**PRICKLEDEN MILLS, WOODHEAD ROAD, HOLMFIRTH, HUDDERSFIELD, WEST
YORKSHIRE HD9 2JU
Application No. 2023/91491**

Historic England Advice

This response relates to amended plans from November 2023. We have responded to a similar proposal on 12th July 2023 and on a similar application on 5th July 2021 and previously in 2012 to an earlier consented scheme, where we gave our response in relation to the significance of Prickleden Mills. This letter should therefore be considered alongside our previous advice.

SECTION A-A 1:200

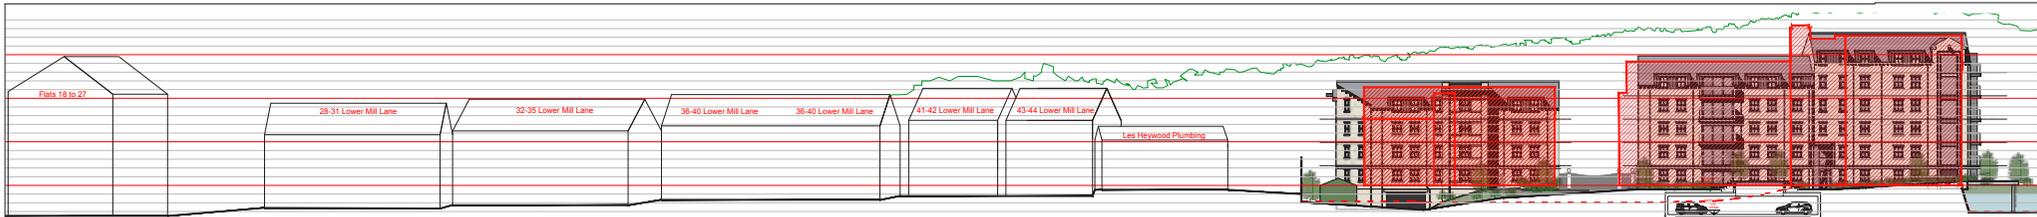
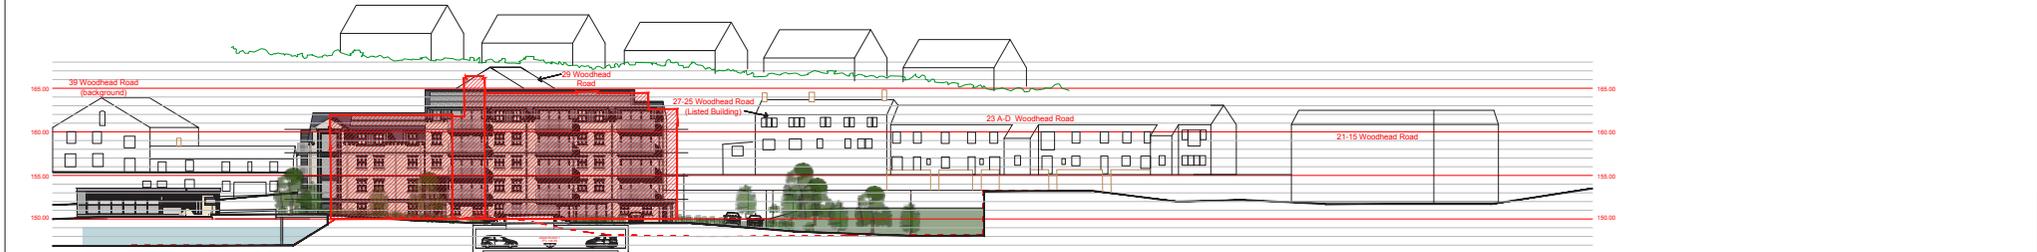
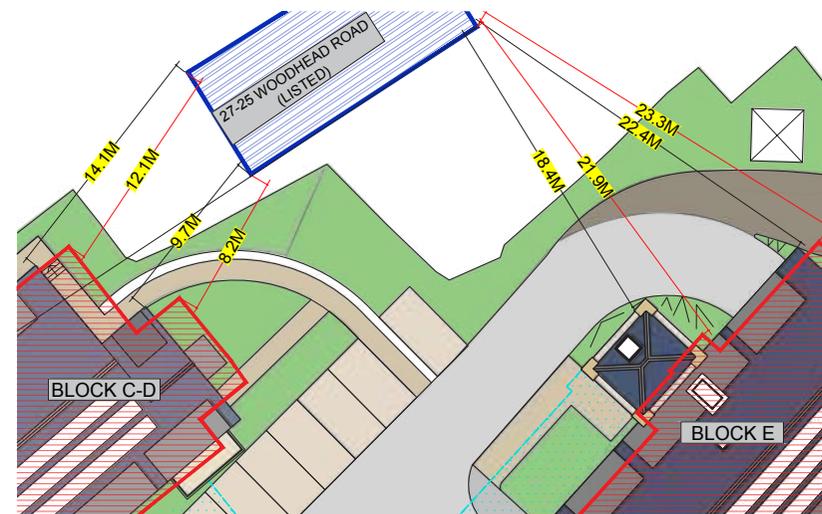
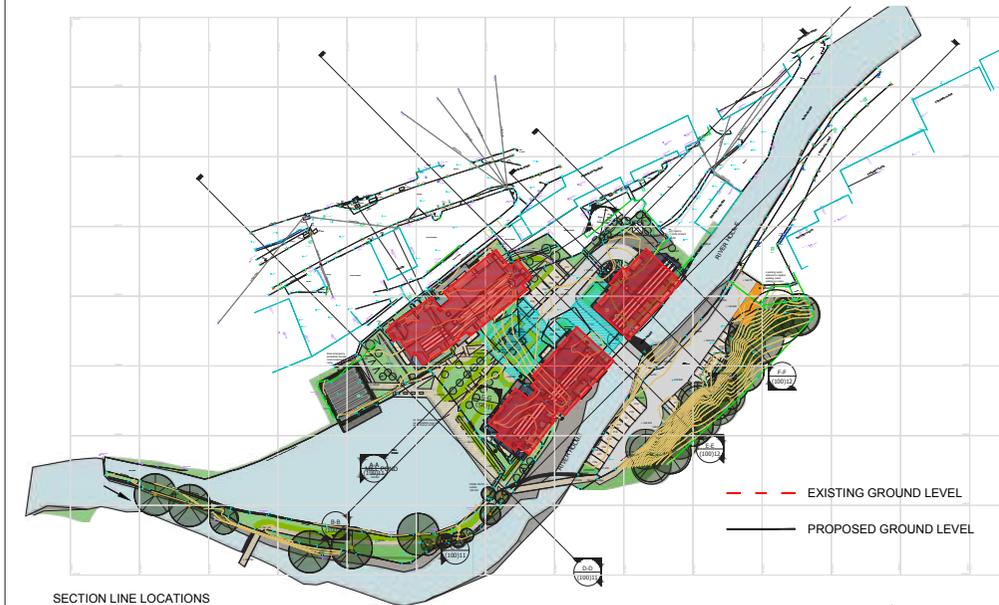
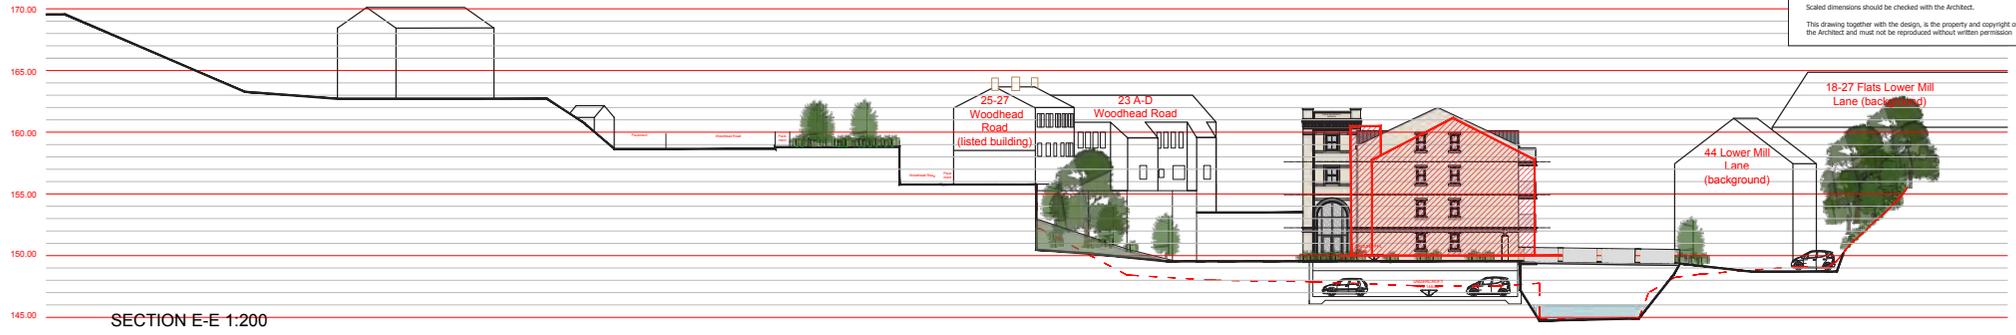
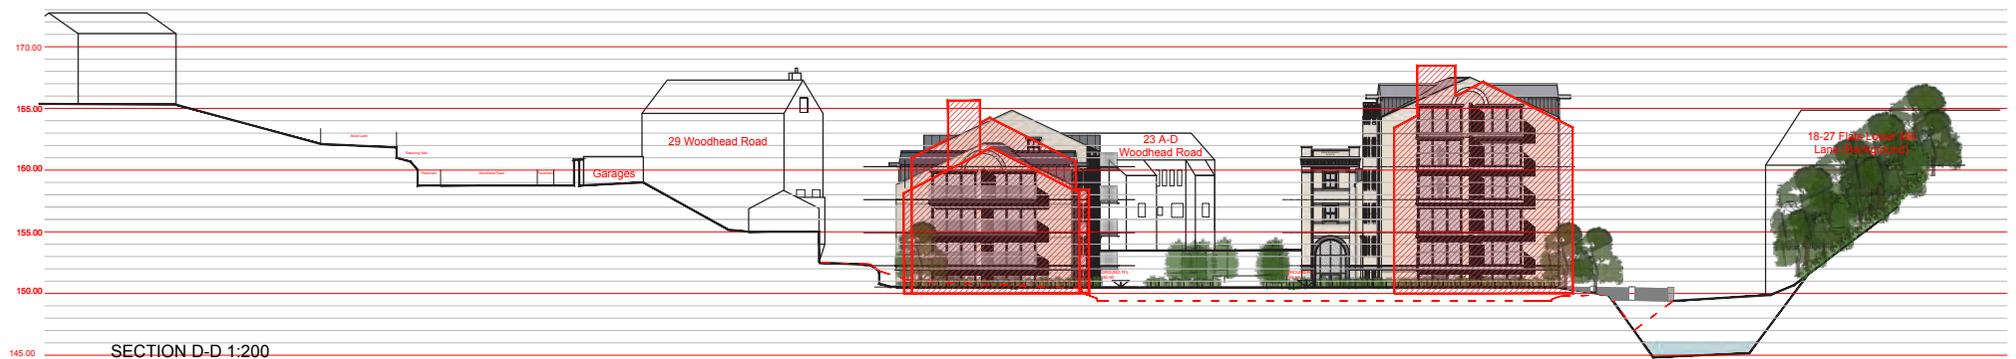
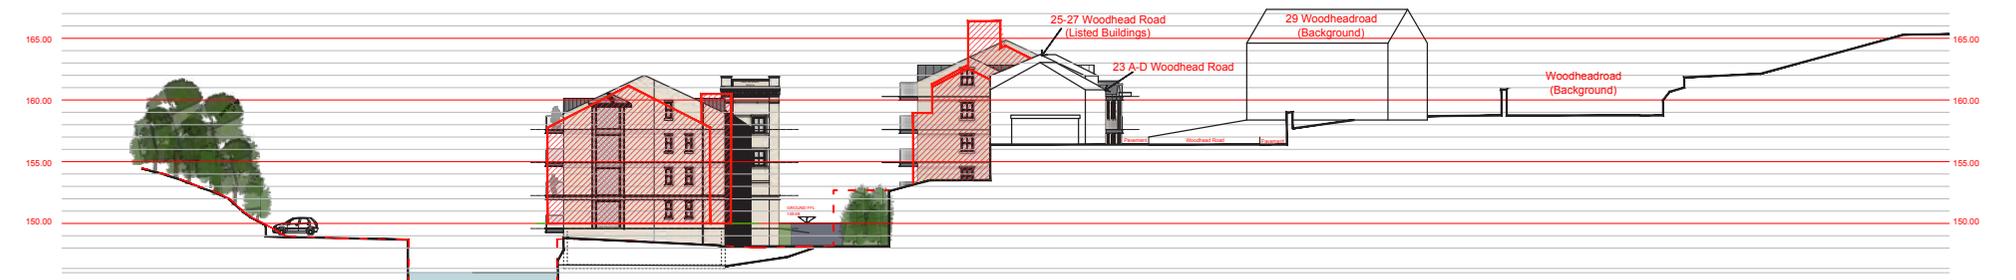
We still consider that the scale of the blocks, particularly blocks C&D, do not relate sensitively

to the domestic scale of the listed buildings nor the buildings in the conservation area. The natural topography of the development site is at the low point of a valley and contributes to the understanding of the history of the mill which was positioned there. Therefore the scale of new buildings should reflect this relationship of the functional mill down in the valley compared to the domestic buildings sited higher up away from the mill/mill pond. Presently the scale overpowers the domestic character of those buildings within the conservation area including the grade II listed buildings.
